**Ann Machado** <amachado@portlandmaine.gov>

11 Amherst St - permit 2017-01280

LEFT ELEVATION
SCALE: 1/4" = 1'-0"

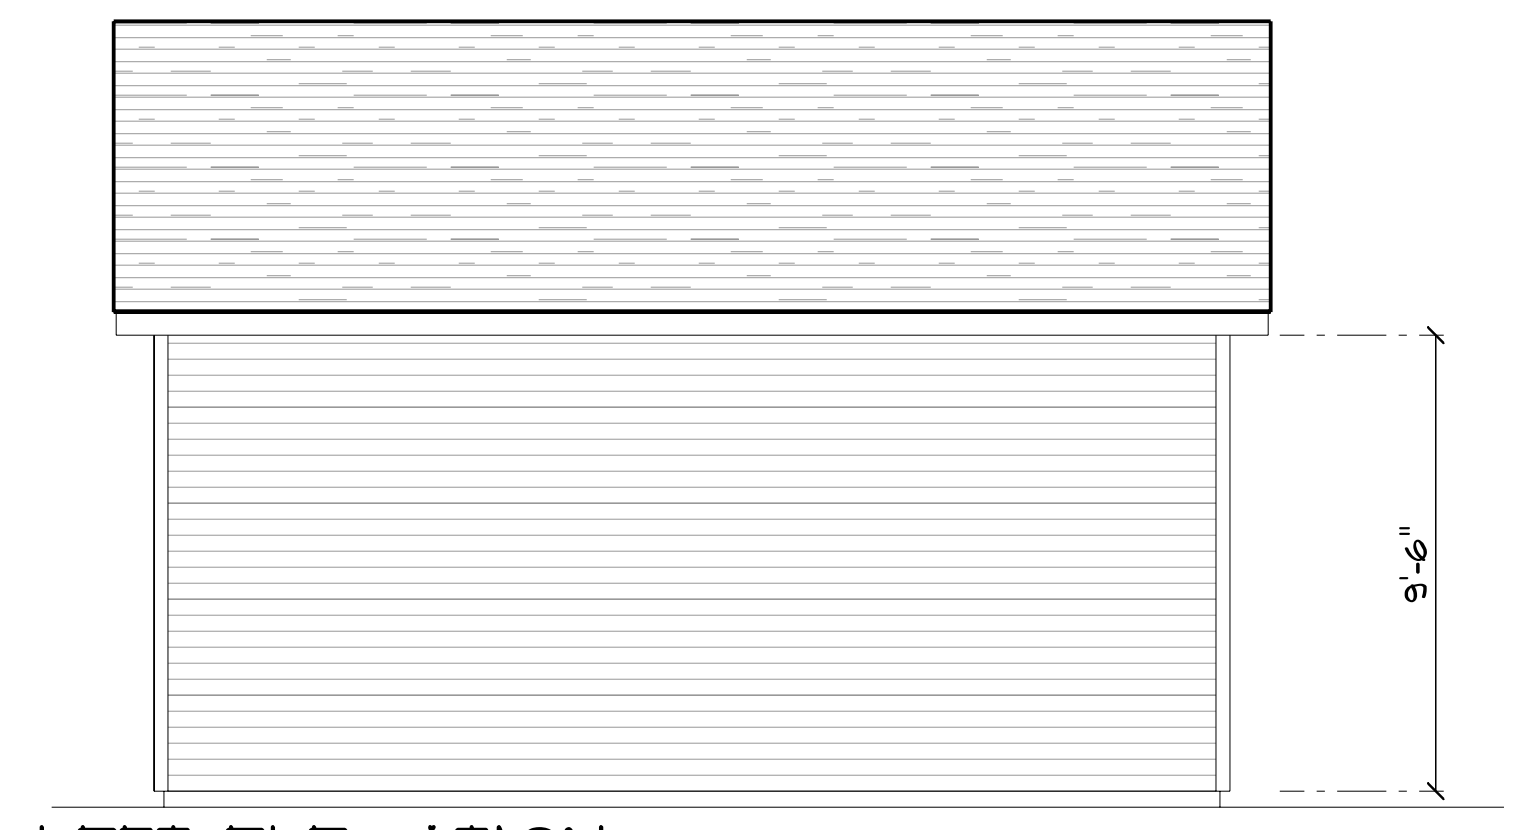
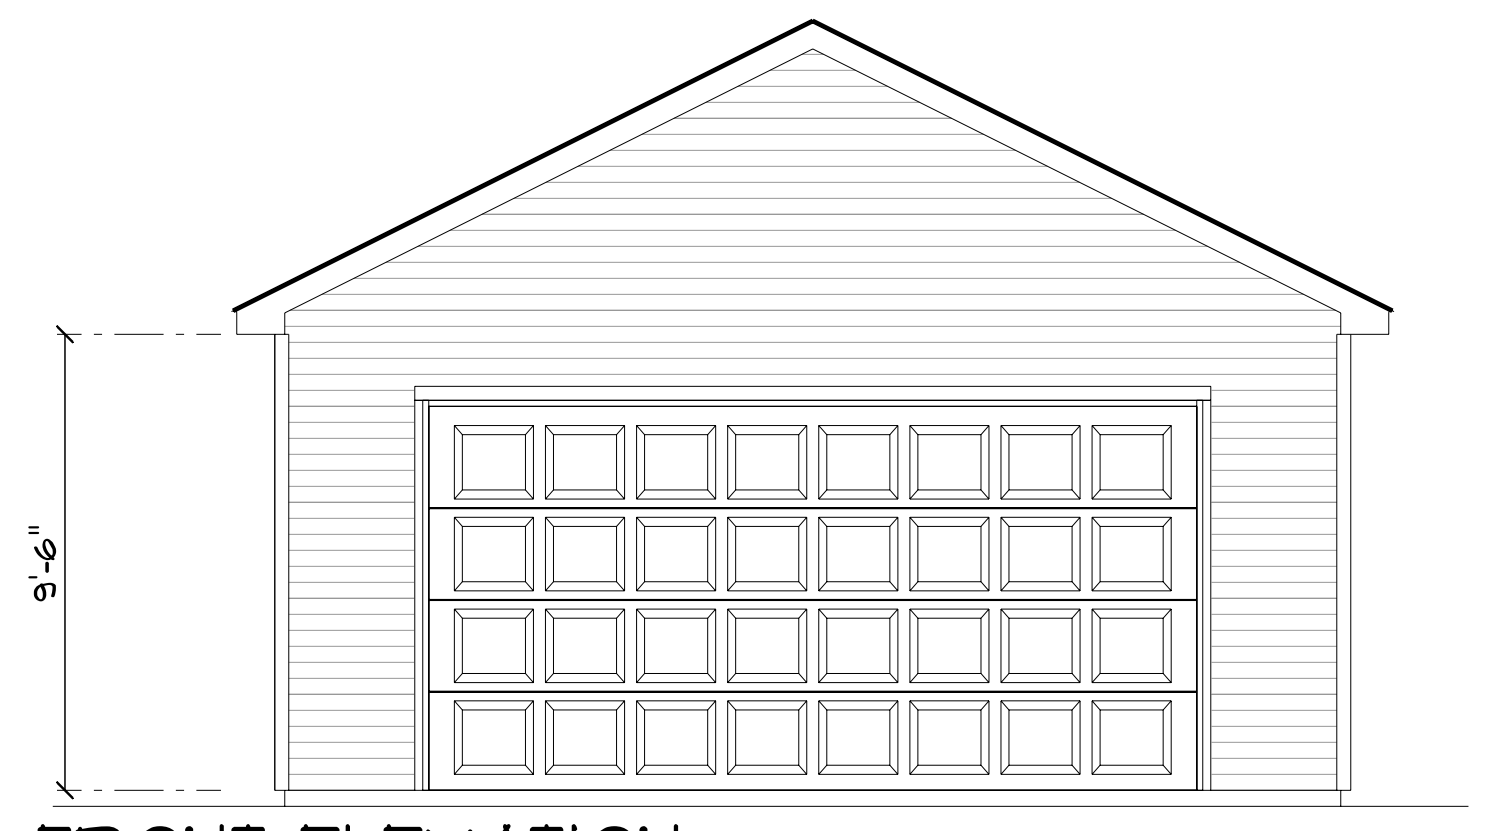
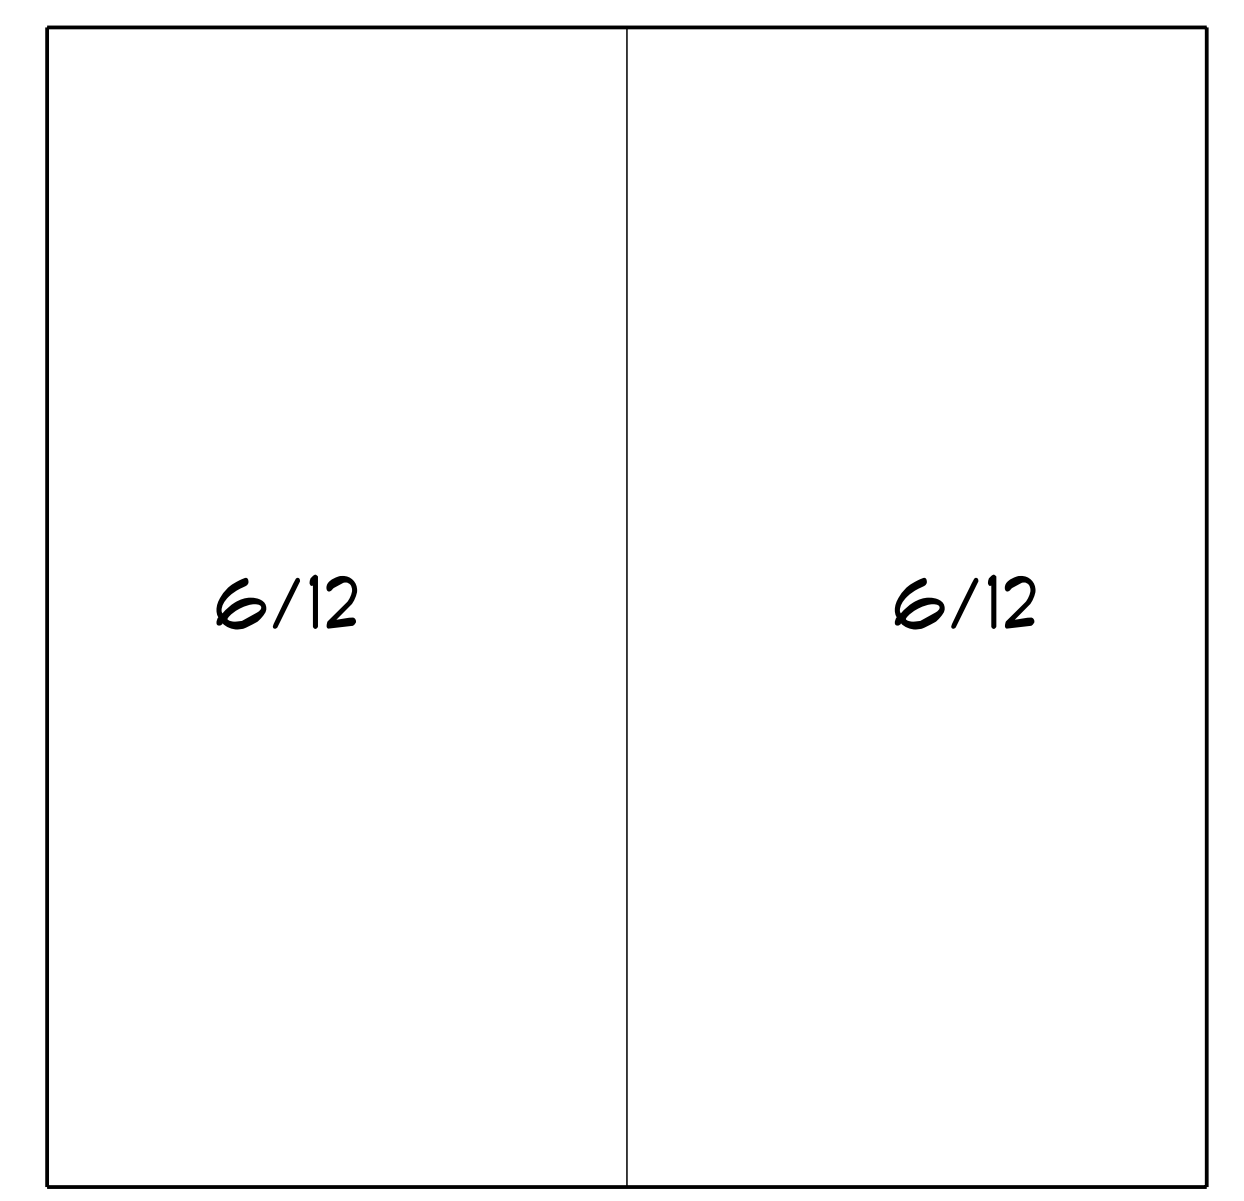
Just following up on our telephone conversation. The new garage will be 22' x 22' with a gable roof instead of a hip roof and the ridge will be lower than the existing garage with the hip roof. . The new garage will be built in the same location as the old garage - 13.5' from the rear property line and how far exactly from the left side property line?

Hi Ann, thanks for the call and the email. All is correct regarding the new dimensions.

Plot Plan - 11 Amherst

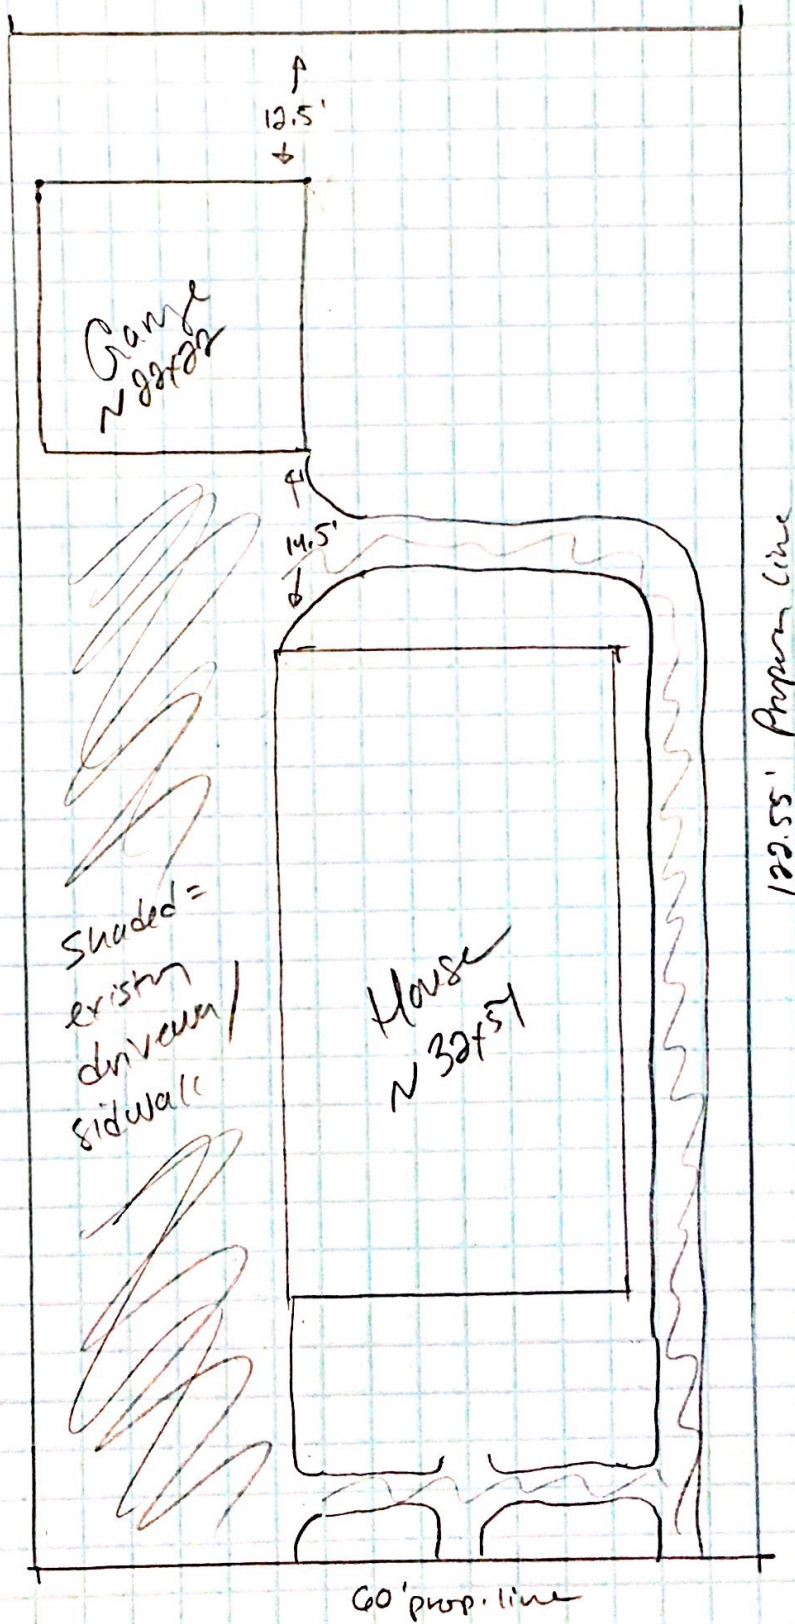
Please confirm this in a return email and include the exact distance of the existing garage from the left side property line.

My measurements have the existing garage less than a foot from the left-side property line. My plan is to rebuild at approximately one foot from the left-side property line.
